Our Ref: AL/68/20/DOC

**Approval of details reserved by condition imposed under ref AL/51/20/PL relating to Condition Nos 10 - surface water drainage and 11 - discharge flows to watercourses**

**Tyrone House Norton Lane Norton PO20 3NH**

Arun District Council have decided to **REFUSE details reserved by condition for the following reasons:**

| DRAWING TITLE<br>DRAINAGE LAYOUT          |            |          |            |             |     |

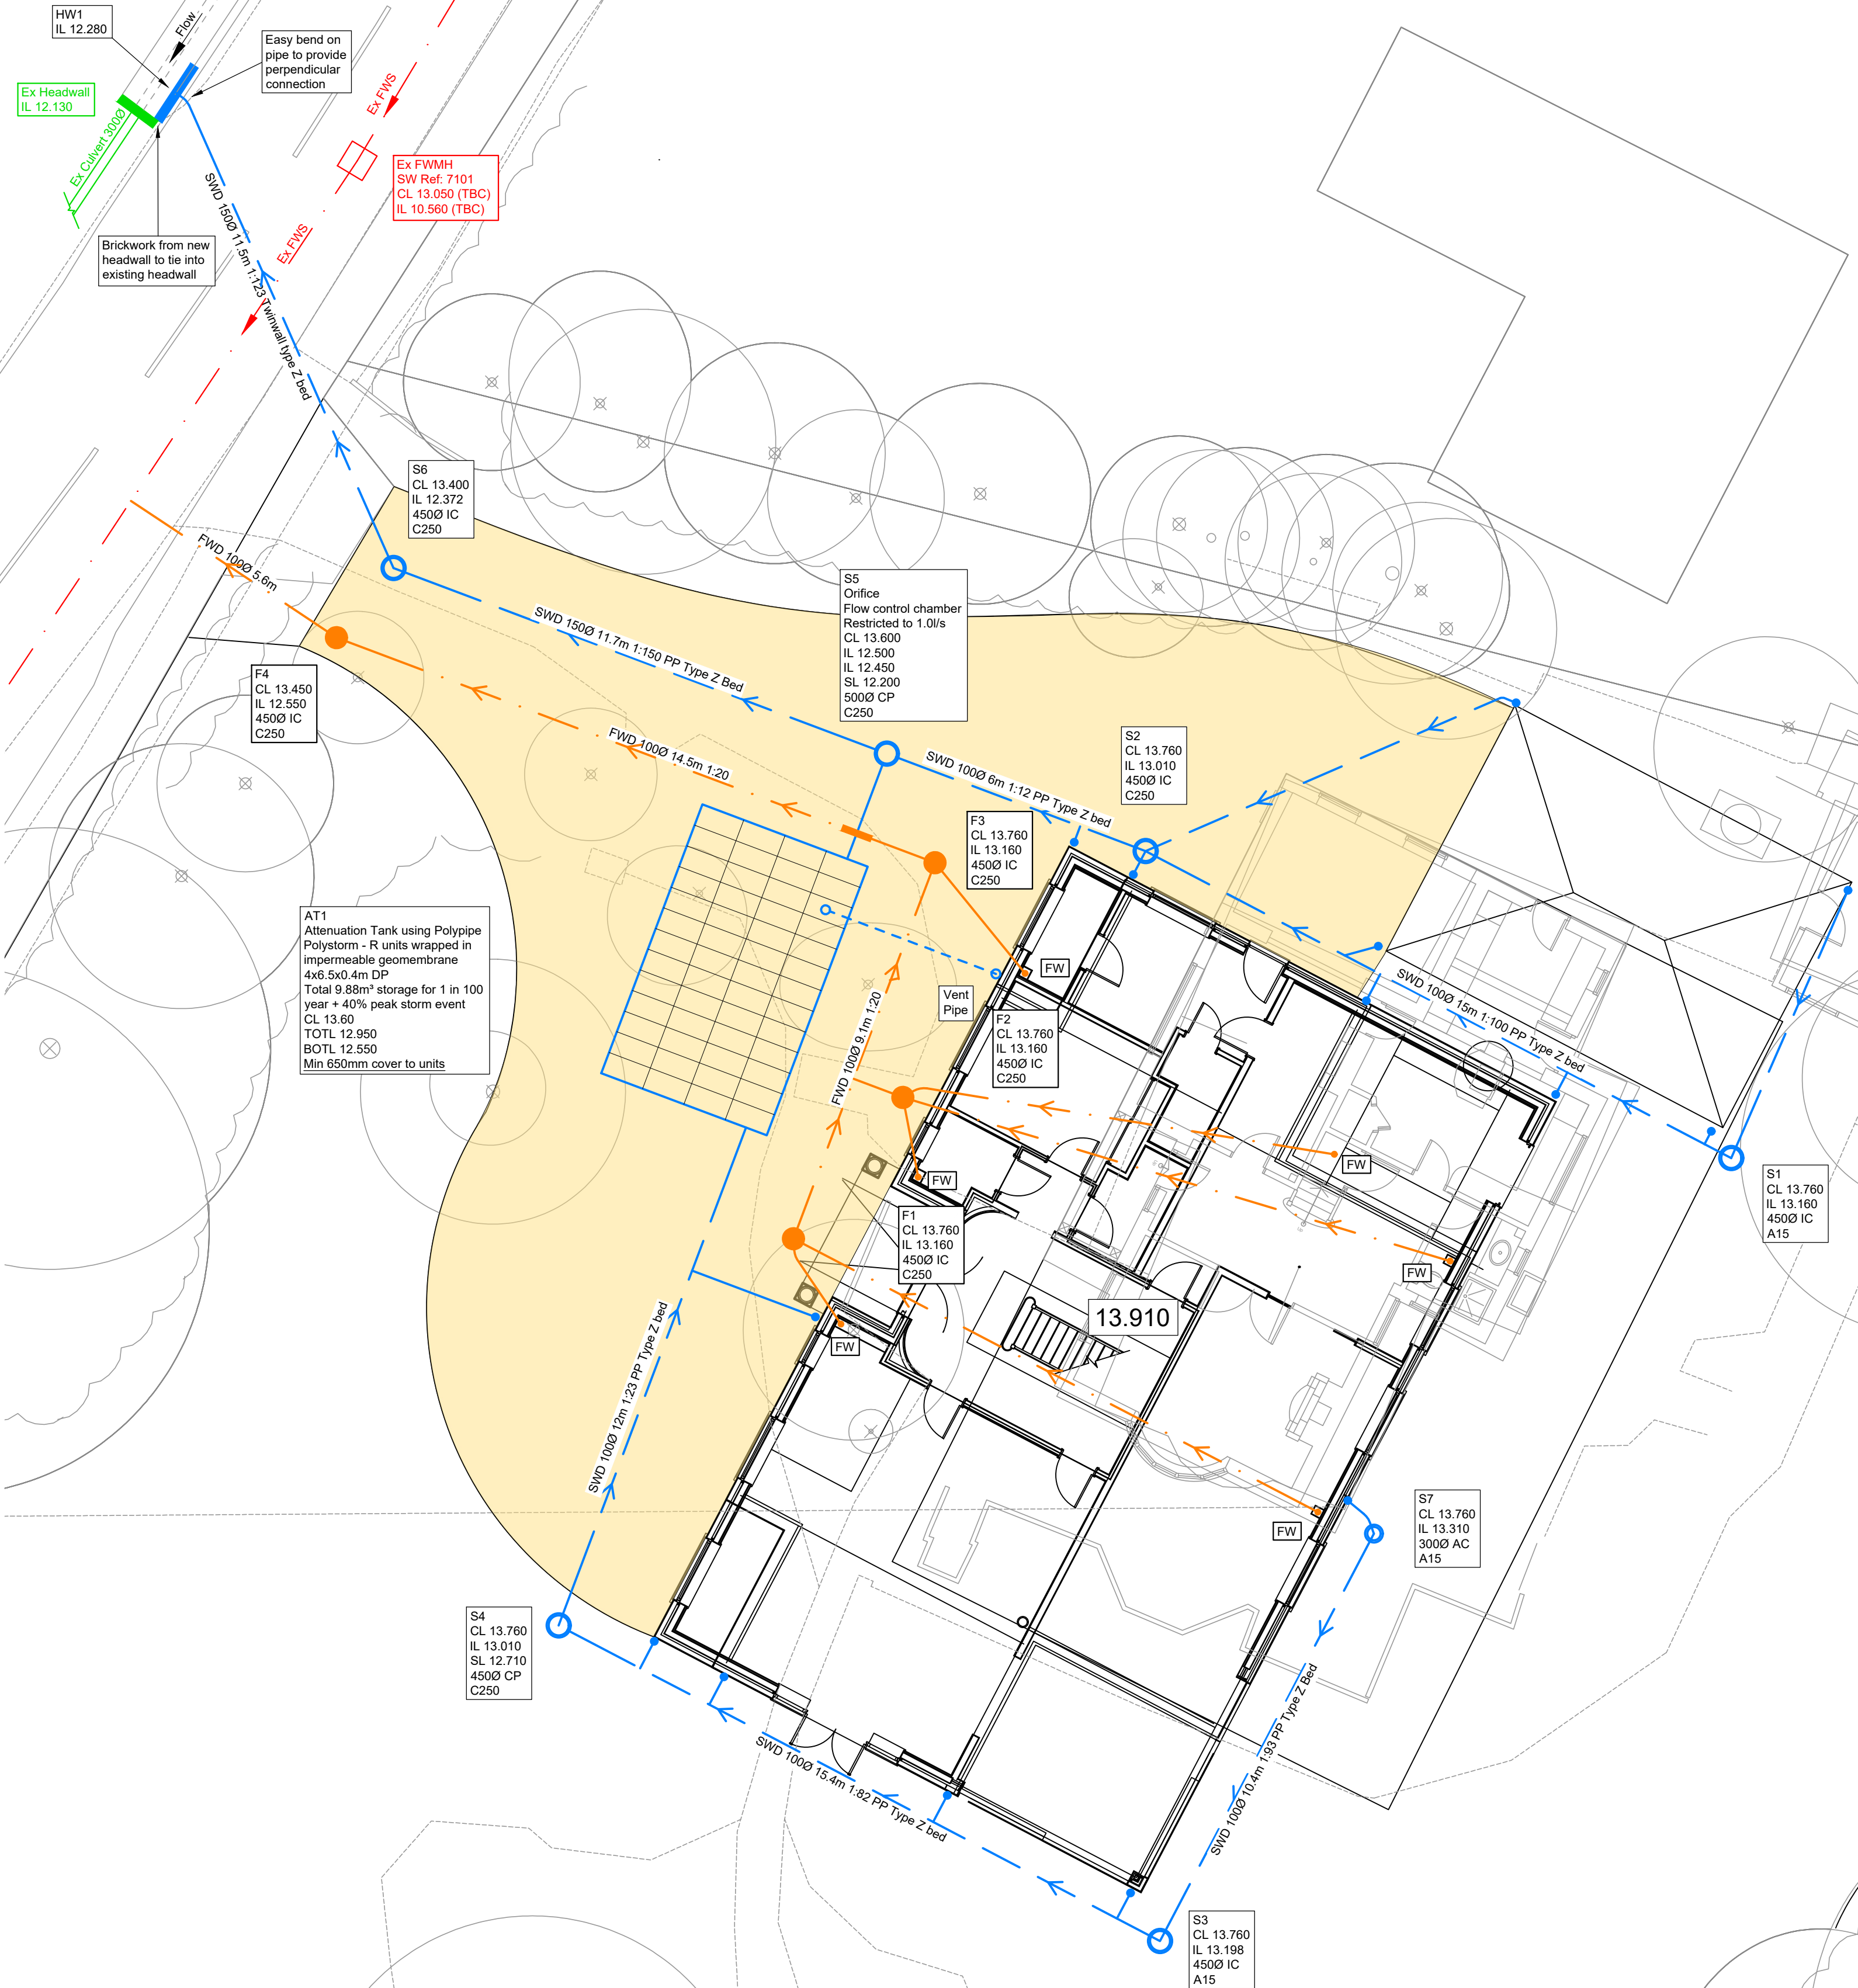
Drainage Officers recommend the discharge condition 10 is refused.

Until it is demonstrated that the site can be drained to an acceptable discharge location it is not possible to approve drainage proposals under this application. Any alterations to discharge location, or point of connection, will impact upon the wider proposed drainage scheme. It is essential to know the

discharge location to be able to assess whether proposals are adequate and will not increase flood risk elsewhere. Relevant policy WDM3

As such, the condition cannot be discharged and you will need to make a revised submission.
